Application by Chrysaor Production (UK) Limited for an Order Granting Development Consent for the Viking Carbon Capture and Storage Pipeline

The Examining Authority's second written questions and requests for information (ExQ2)

Published on Monday 12 August 2024

TITLE THE IMMINGHAM FACILITY PLOT PLAN

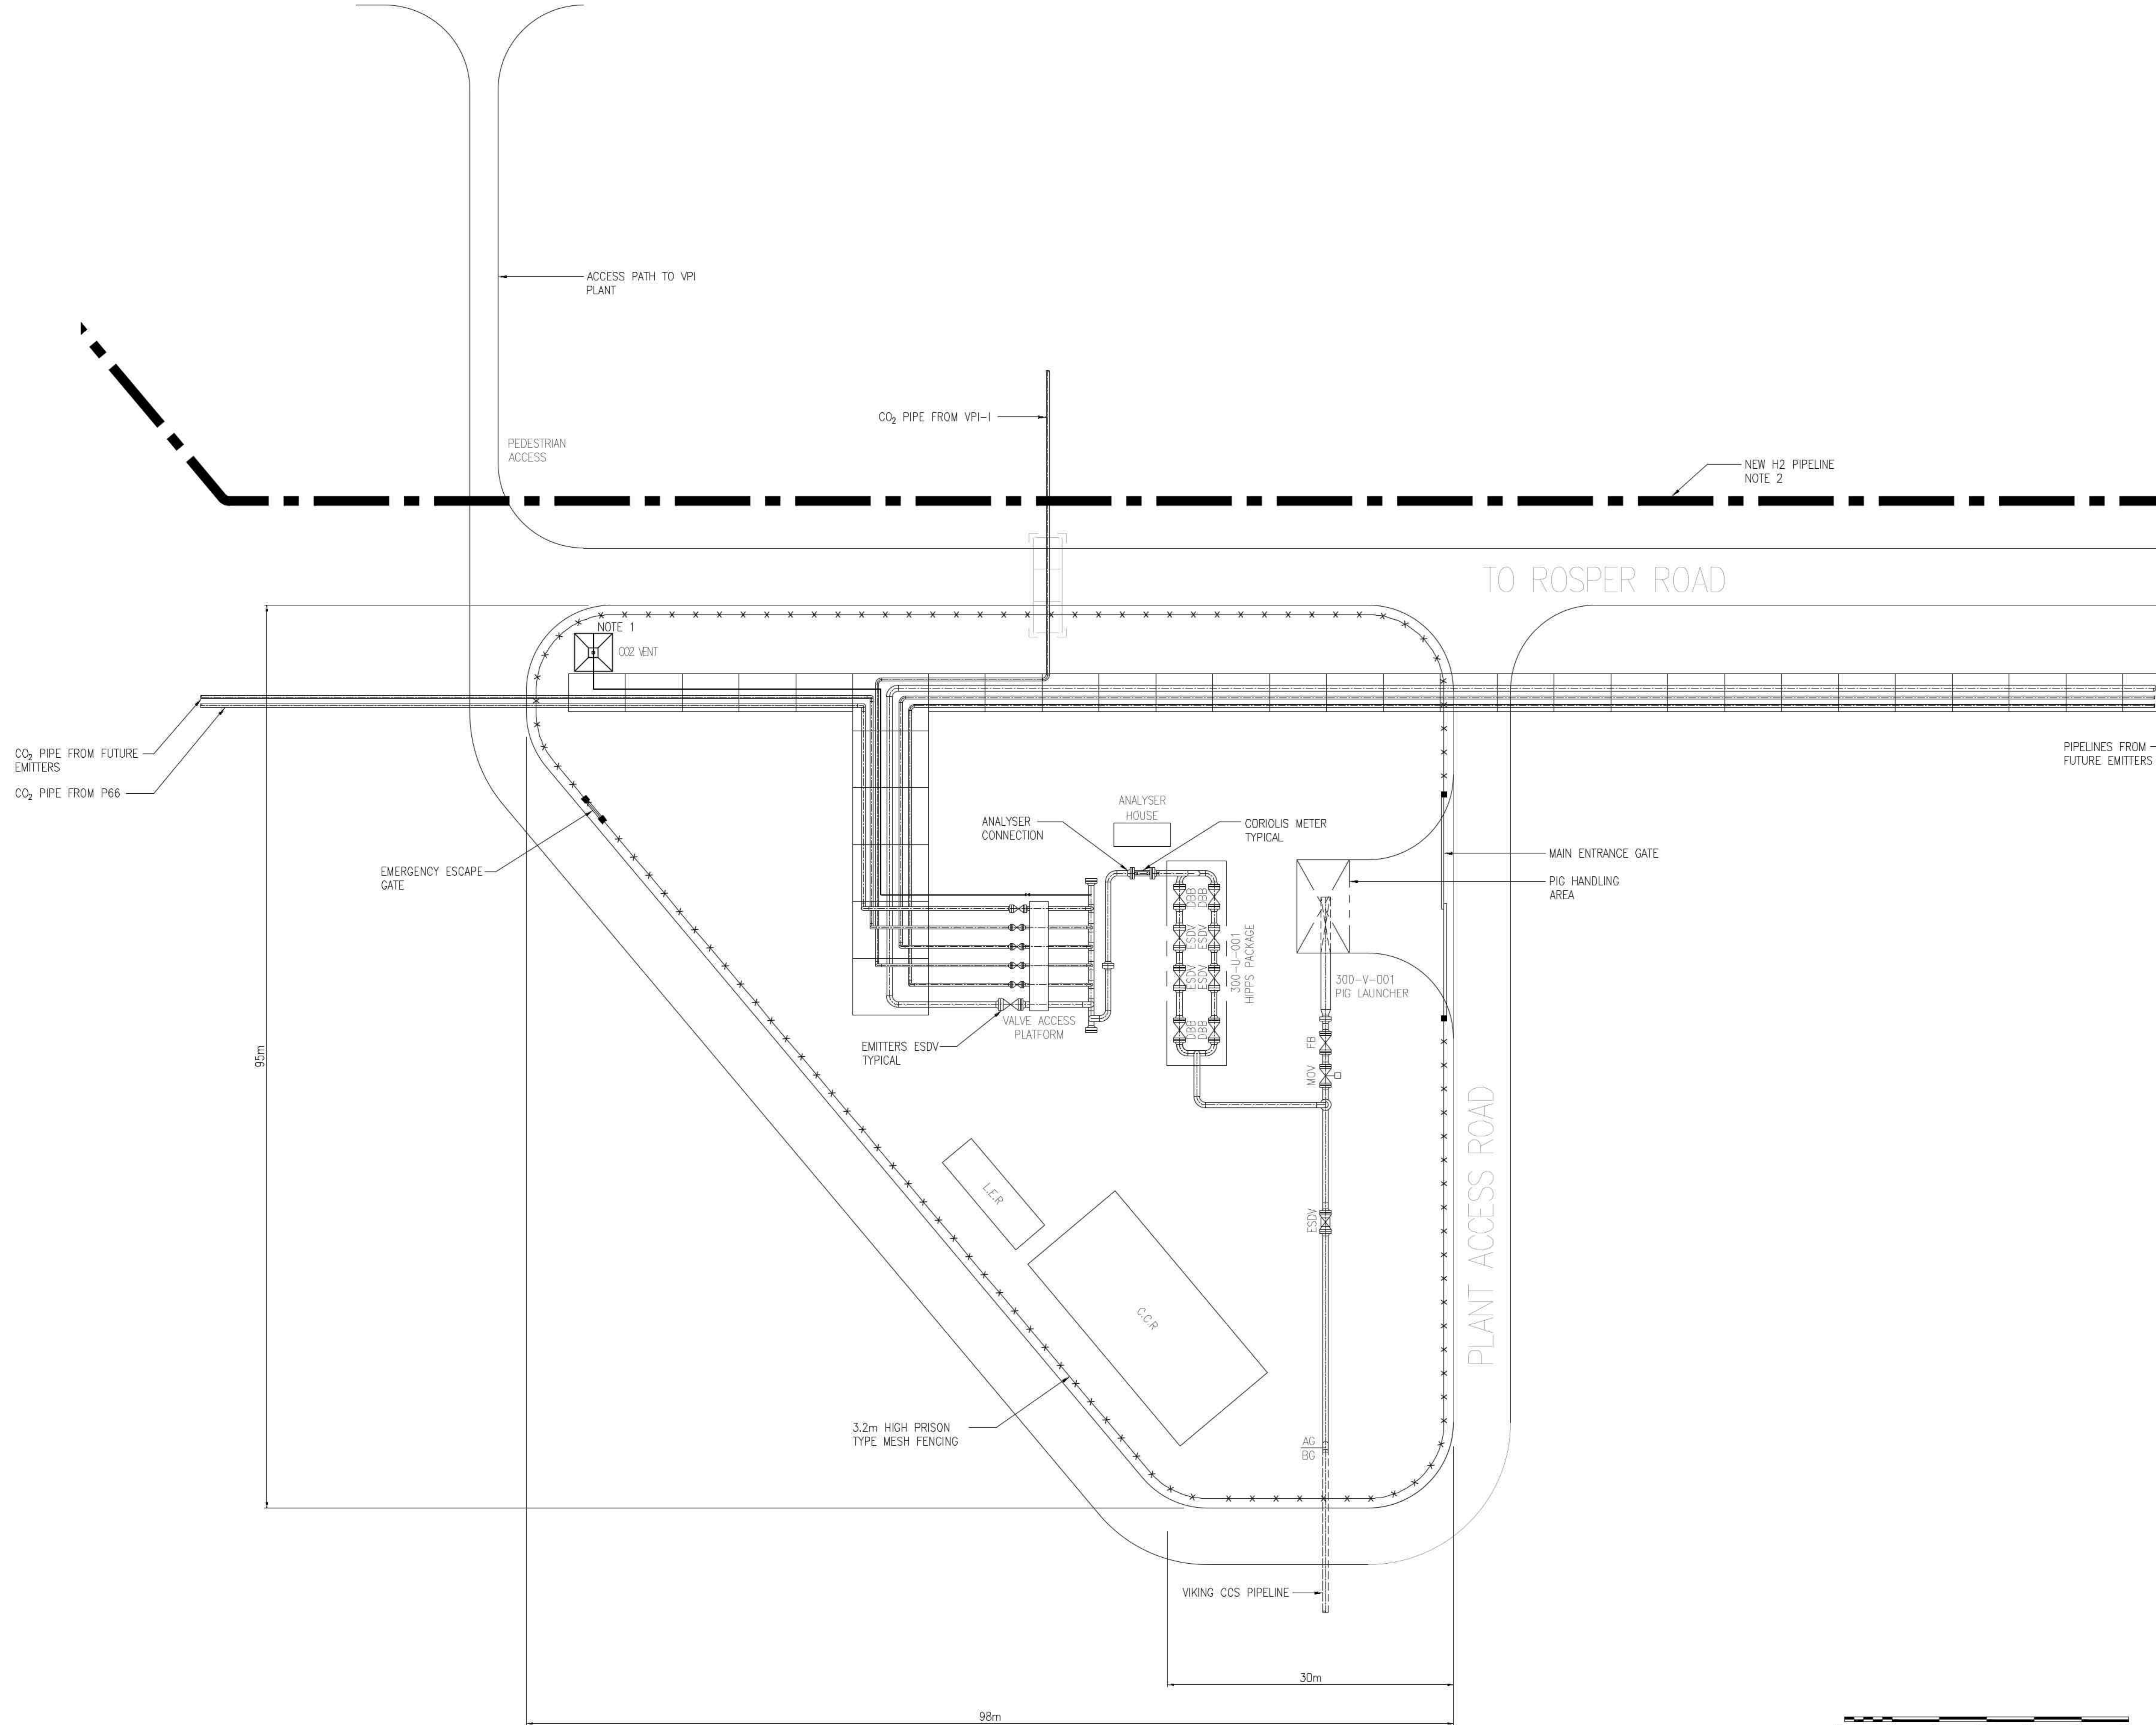
2.1.3	Applicant	<p>Immingham Facilities Plot Plan</p> <p>For absolute clarity, can it be confirmed that the indicative Immingham Facilities Plot Plan [APP-019] does not need to change following the first change request [AS-038].</p>
Major Hazards and Accidents
